**Kevin Cox**  
**Crime Prevention Design Advisor**  
Thames Valley Police Headquarters South  
Oxford Road  
Kidlington  
Oxfordshire  
OX5 2NX

REF: 22/03063/F

Location: Land East Of Larsen Road Heyford Park

### **Holding Objection**

Engineering Plan

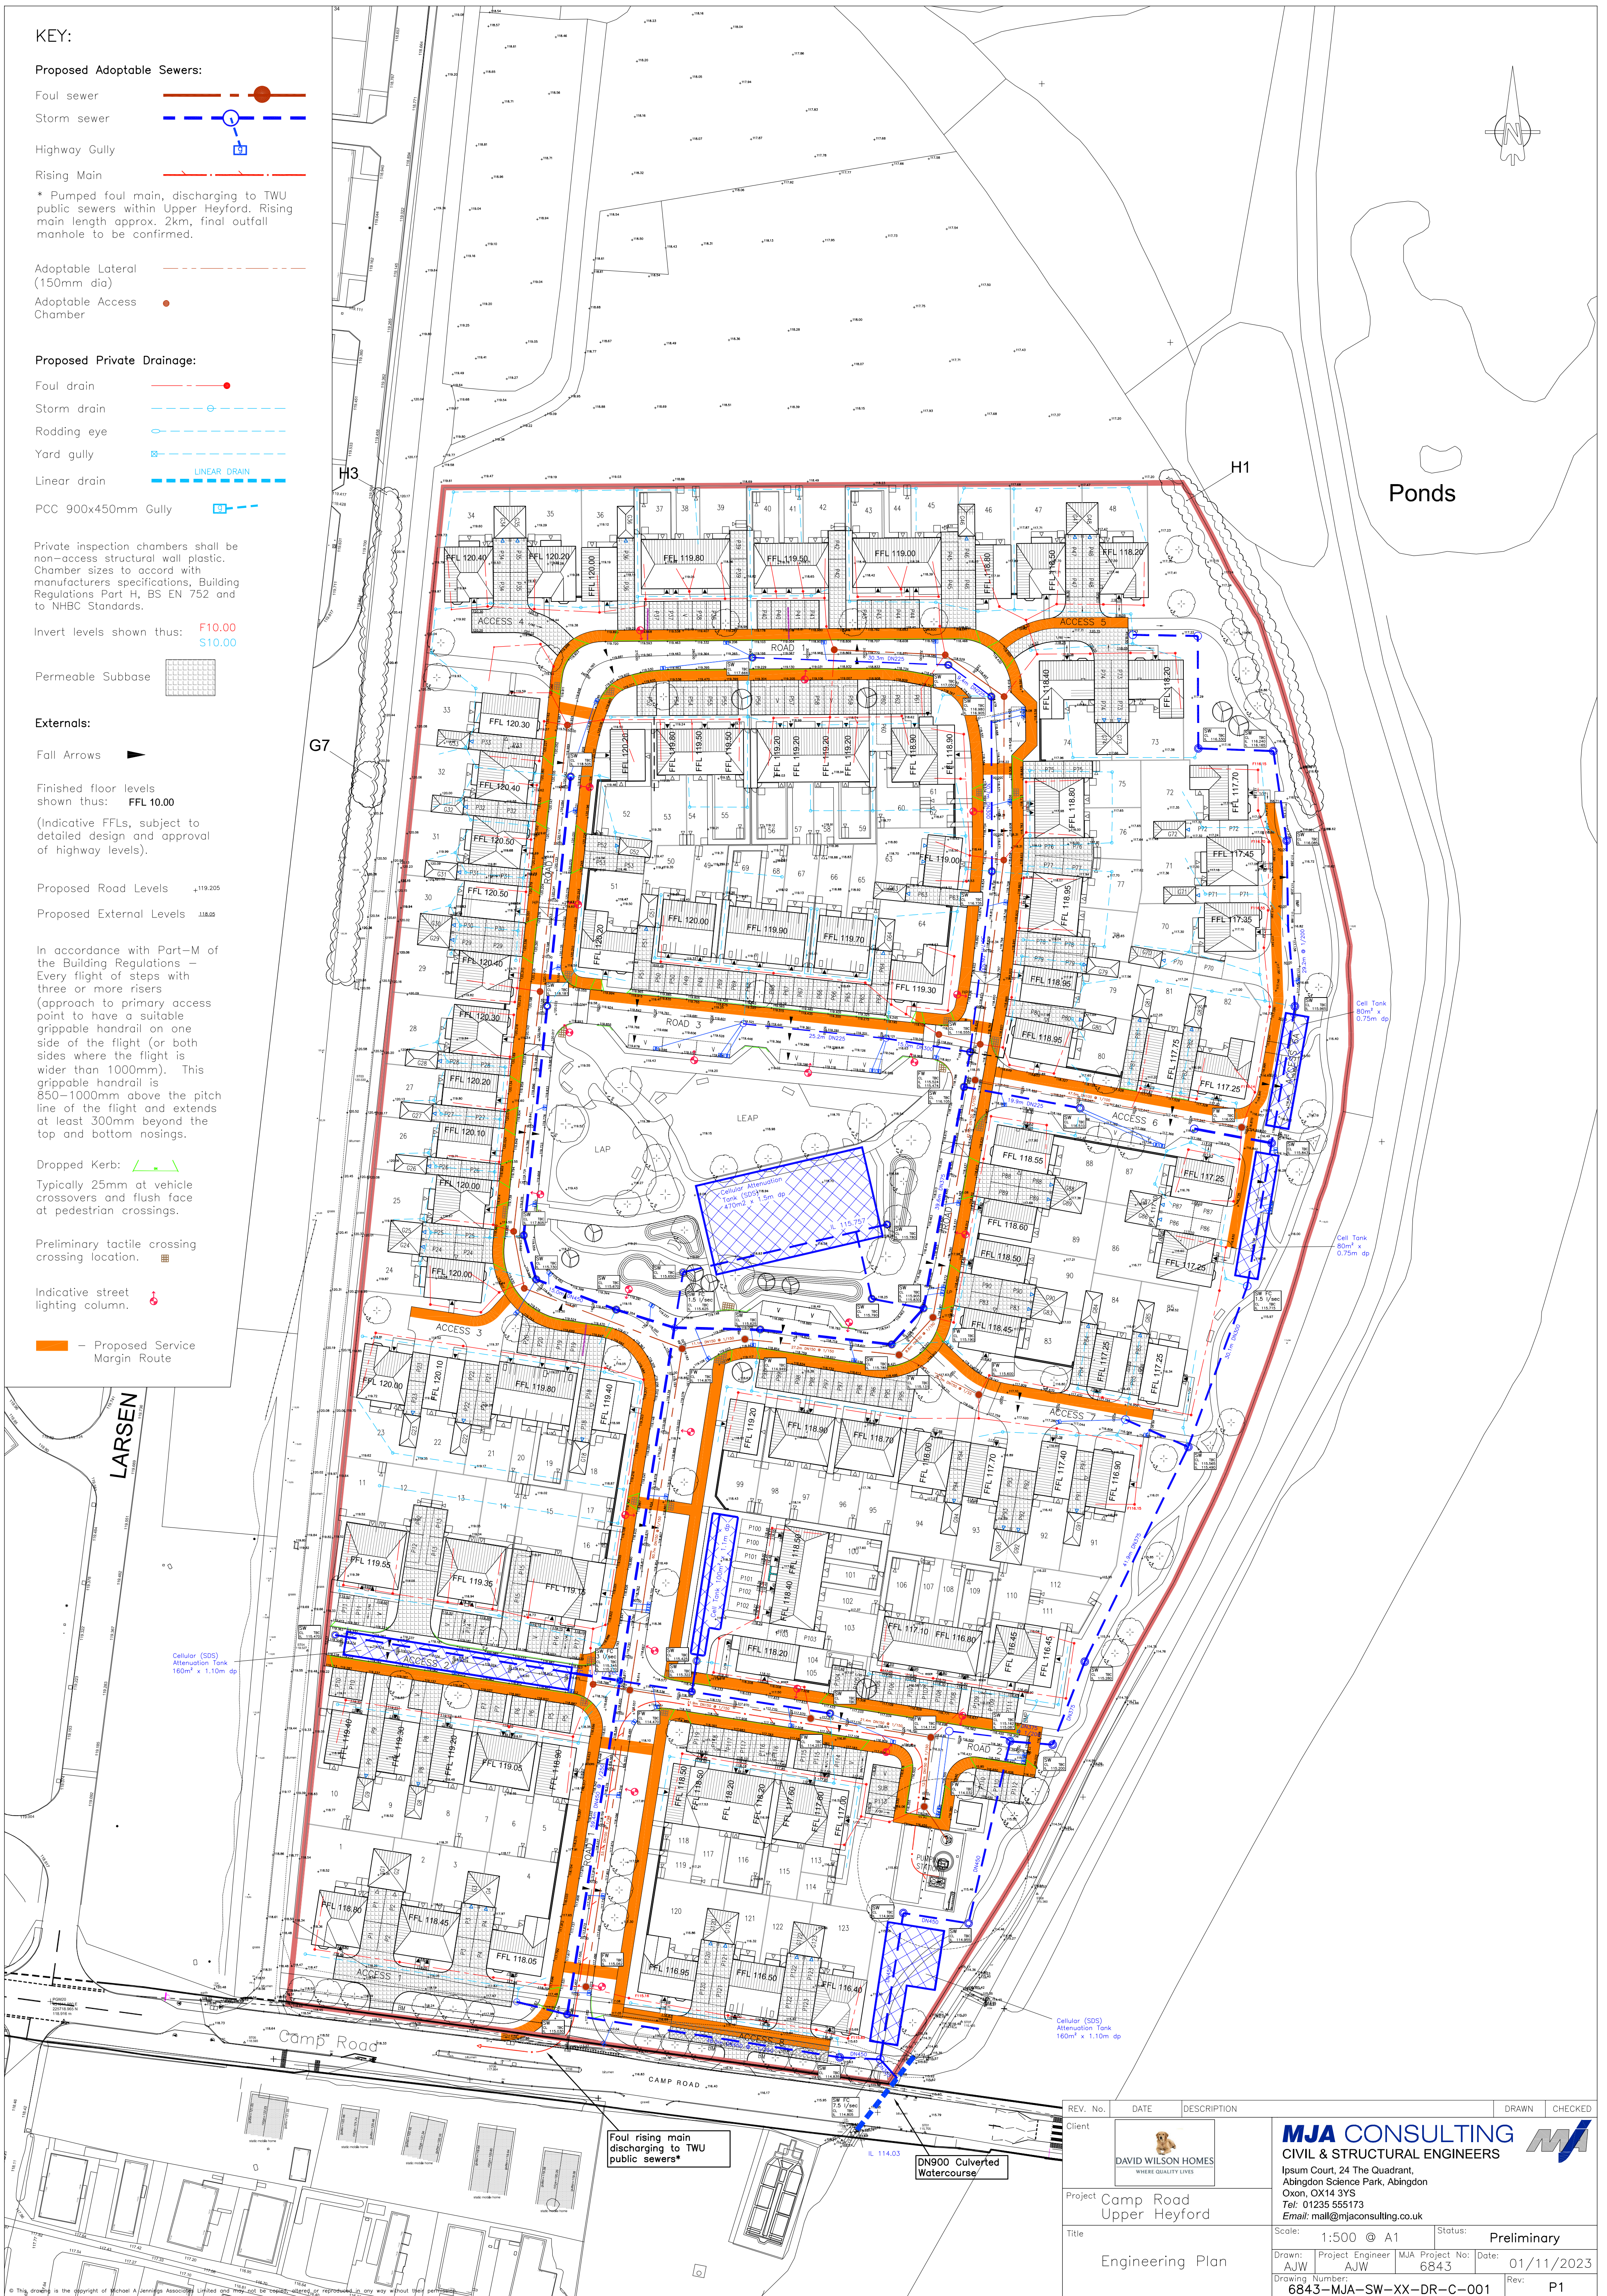
The BCP located to the rear of plots 102/103 leaves these plots vulnerable to unauthorised entry and crime such as burglary, as the bins are located where they could be easily used as a climbing aid to gain access to the rear gardens. I ask that this BCP is located away from residential boundaries to prevent bins being used to facilitate crime.

- Plots 116 and 126 are at risk of unauthorised entry and crime, due to having vulnerable side/rear elevations easily accessible from the public realm whilst significantly lacking surveillance. The location of the pumping station creates an ambiguous area of open space that will be vulnerable to crime and ASB, and exposes these plots excessively. I ask that this area of the development is reconfigured to provide adequate surveillance and protection to these very vulnerable plot boundaries.

The development is designed with long straight sections of road throughout, which are going to be very vulnerable to issues of excessive speed and a negative impact on the community. I ask how the applicant proposes to restrict and control speeds throughout the development, without having to rely on police enforcement action. Ideally roads should incorporate frequent deviations in direction, chicanes or other build out features to physically restrict the speeds achievable throughout the development.

It is unclear what side/rear boundary treatment is proposed for the row of plots to the west of the development including plots 1, 11, 12, 25-37 and the northern row 37-51 where they meet the edge of the development. These plots appear particularly vulnerable to crime and burglary, where exposed side/rear elevations are easily accessible from the public realm whilst lacking sufficient surveillance from surrounding development. In addition, there is a risk that residents may consider fly tipping garden waste and other items over their rear boundary into adjoining land, where they cannot see it and no one else would see it being tipped (particularly to the north).

The long stretch of rear boundaries facing onto the public footpath also creates a significant risk of crime and antisocial behaviour occurring along this footpath, due to the complete lack of surveillance overlooking it. Wherever public footpaths are provided, they should be protected from crime and ASB by having high levels of active frontage and surveillance overlooking them.

I am unable to locate any lighting plans within this application. Lighting throughout the development should meet the general standards of BS5489-1:2020. Lighting plans should be provided which should set out how this standard will be achieved not only on adopted highways, but also un-adopted roads and parking areas. Bollard lighting is not an appropriate lighting method, and should be avoided. Not only can they be damaged by reversing vehicles, more critically they do not provide sufficient light at the right height to aid facial recognition and reduce the fear of crime. It also does not deter crime and antisocial behaviour.

I have concerns that the proposed “Kick about / active area” is located in an area surrounded with parking and roads, but without any boundary treatments to contain activities taking place within this space. If ball games were to be encouraged in this area, there is a high risk of balls escaping the space and causing damage to vehicles parked in the visitor parking adjacent, or escaping into the road. This creates a risk of children running out into the road after balls, and also a risk of neighbour disputes and community tension in the case of accidental damage to vehicles. Any outdoor space where ball games are encouraged or permitted must be located in an area that is suitably located away from the road/parking and enclosed with boundaries to prevent these incidents from occurring.

The area of public open space is also located directly opposite a long straight section of road, leaving users very vulnerable to accidental or deliberate vehicle incursion into this space. Due to the potential speeds achievable on the run up to this area of public open space, it would be necessary to provide vehicle mitigation measures to prevent vehicular incursion into the area of POS, in the location as indicated below. In any case, areas of green space must be provided with landscaping or physical features to prevent unauthorised vehicular incursion onto areas of open space.

It is vital that these exposed boundaries are sufficiently protected from unauthorised entry by the use of robust boundary treatments that are backed up with defensible planting, that I recommend is of mature age and dense enough to restrict access up to the boundary. Use of thorny species such as Pyracantha or Hawthorne would be particularly beneficial in areas such as these.

To reduce the risk of fly tipping, it has been seen that the use of robust vertical hit and miss fencing reduces incidents of fly tipping over the rear boundary, as whilst the boundary is sufficient to resist intrusion, residents are able to see the land beyond.

I ask that lighting plans should be provided prior to permission being granted. Alternatively, I ask that the following or similarly worded condition be placed upon the approval;

***Prior to commencement of development, details of a proposed external lighting scheme shall be submitted to the local planning authority. The scheme shall set out the steps that will be taken to ensure that external lighting, including zonal/security lighting and column lighting within parking courts promotes a secure environment and does not cause a nuisance to local residents.***
